RE: Pymble Ladies College Grey House Precinct – DA Letter
Avon Road, Pymble, NSW 2073

This letter relates to the Fire Safety design aspects of the proposed PLC Grey House Precinct development of a multi-purpose Education, Sports, Recreation and Performing Arts school building located at Avon Road, Pymble NSW 2073, and specifically to those Fire Safety design aspects that impact on planning and correspondingly on Development Approval issues.

A Fire Engineering review of the preliminary design has been undertaken by Stantec based on the following:

#### SECTIONS

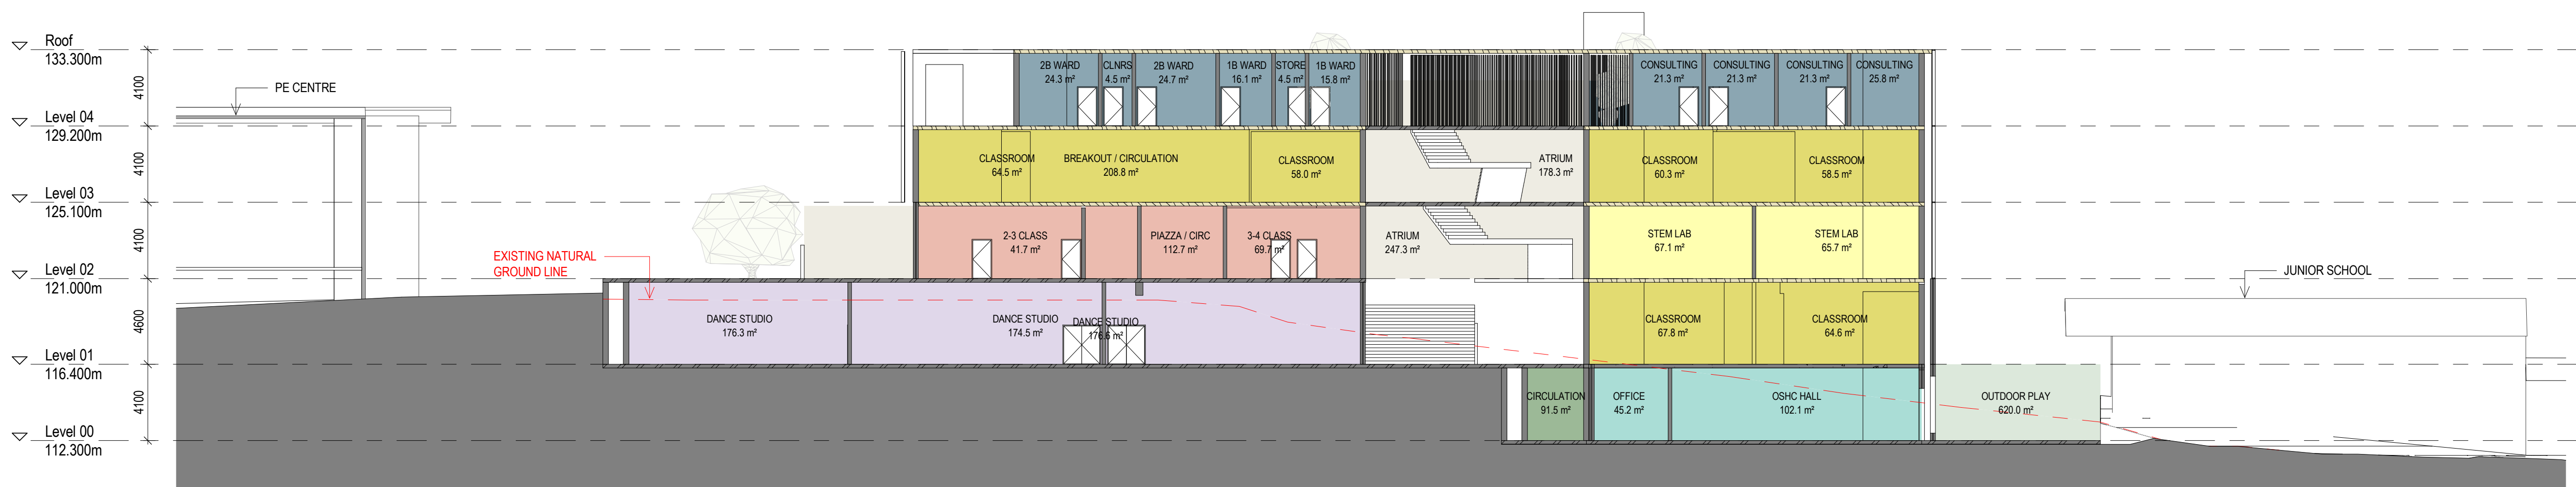
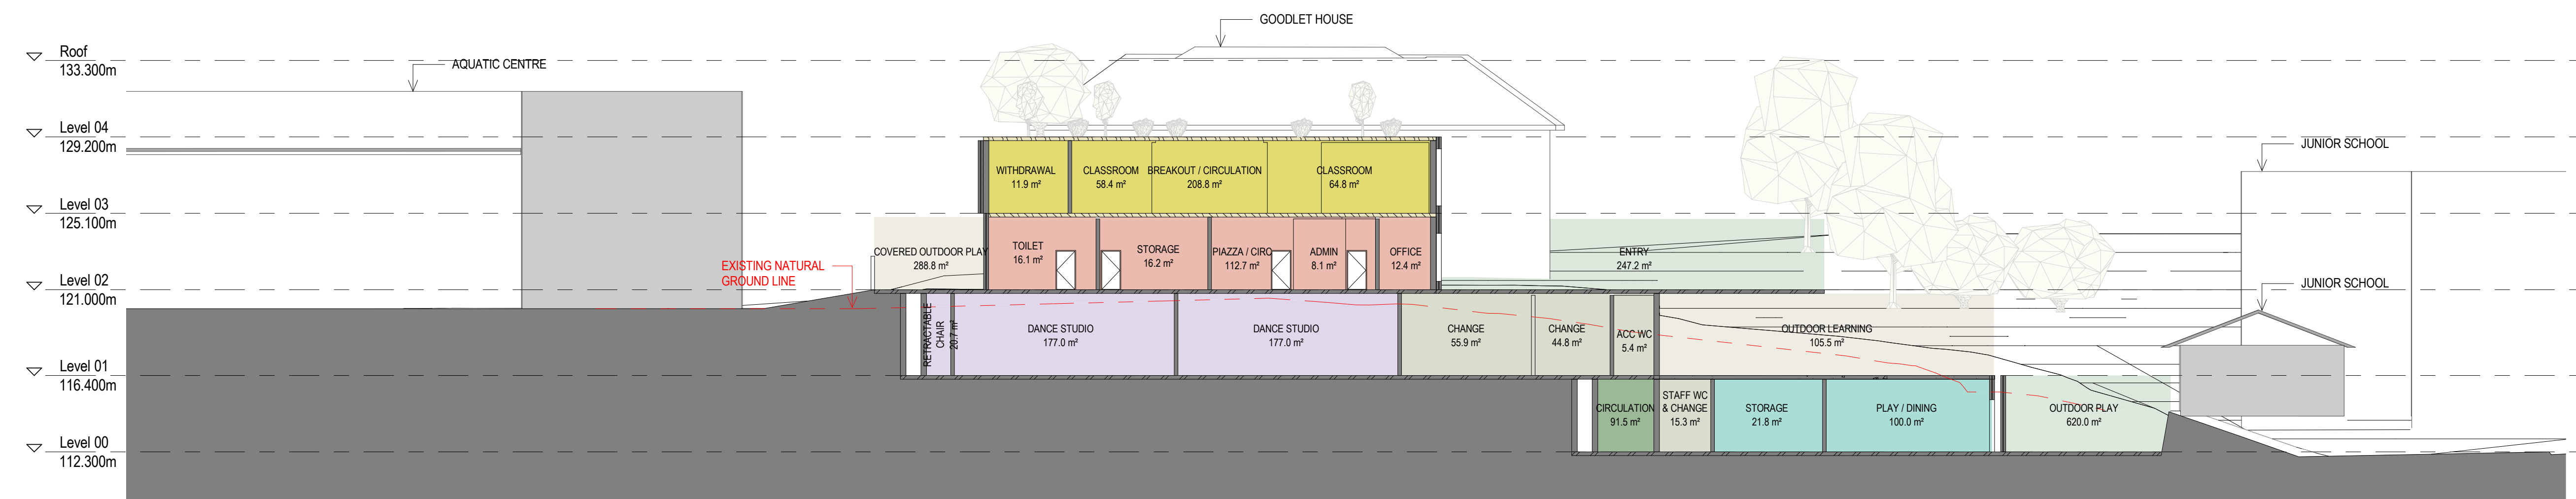
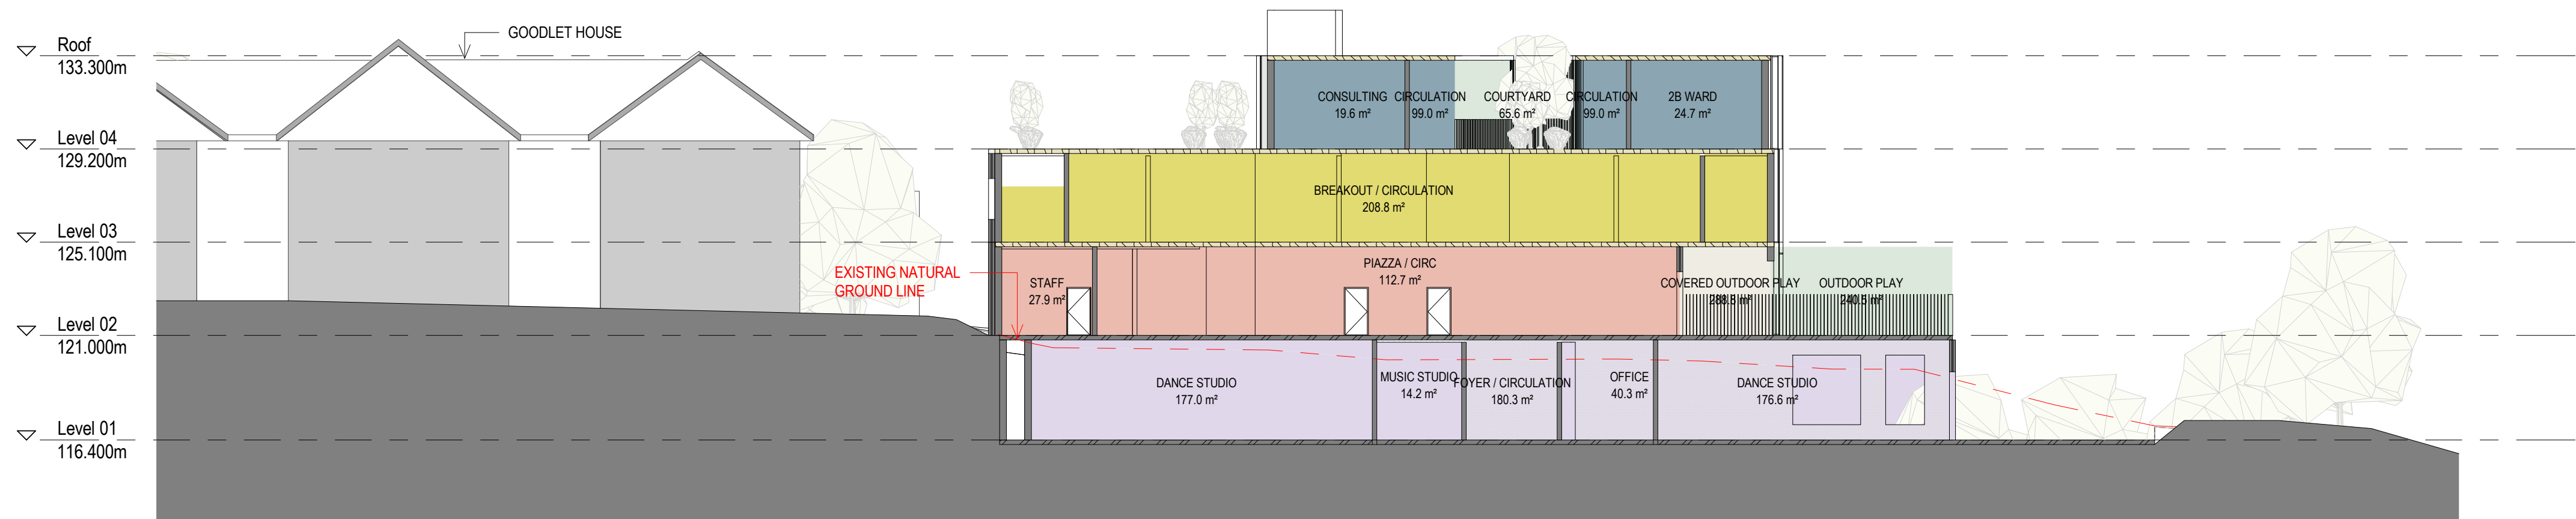
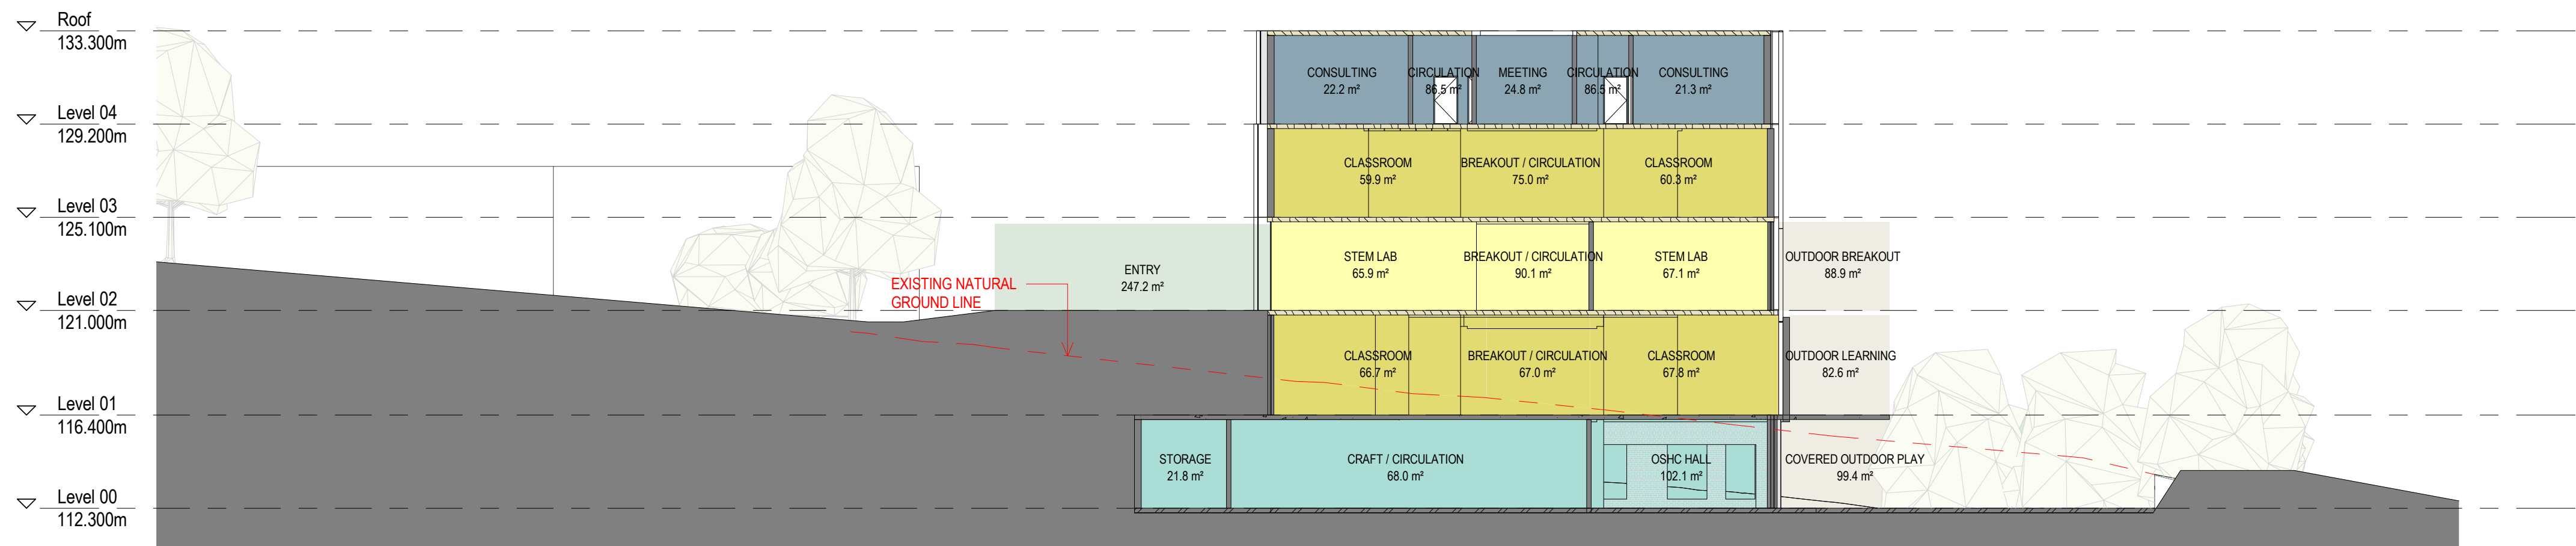
Item	Non-Compliance	Description	Strategy/Comment
6	Atrium construction (G3.1 to G3.8)	The building is required to comply with the requirements for Atrium Construction part G3 as the central stair void through the building is connecting Level 1 to Level 4 which forms an atrium well i.e., connects 4 stories & this does not get the concession as noted in Clause G3.1.	Due to the open and low hazard nature of the atrium space, the typical hazards associate with atriums are not applicable in this case and hence the omission of atrium requirements could be justified via a Performance Solution. The Performance Solution will rely on smoke separation between the atrium space and the rest of the building to reduce any risk of early smoke spread during an evacuation.
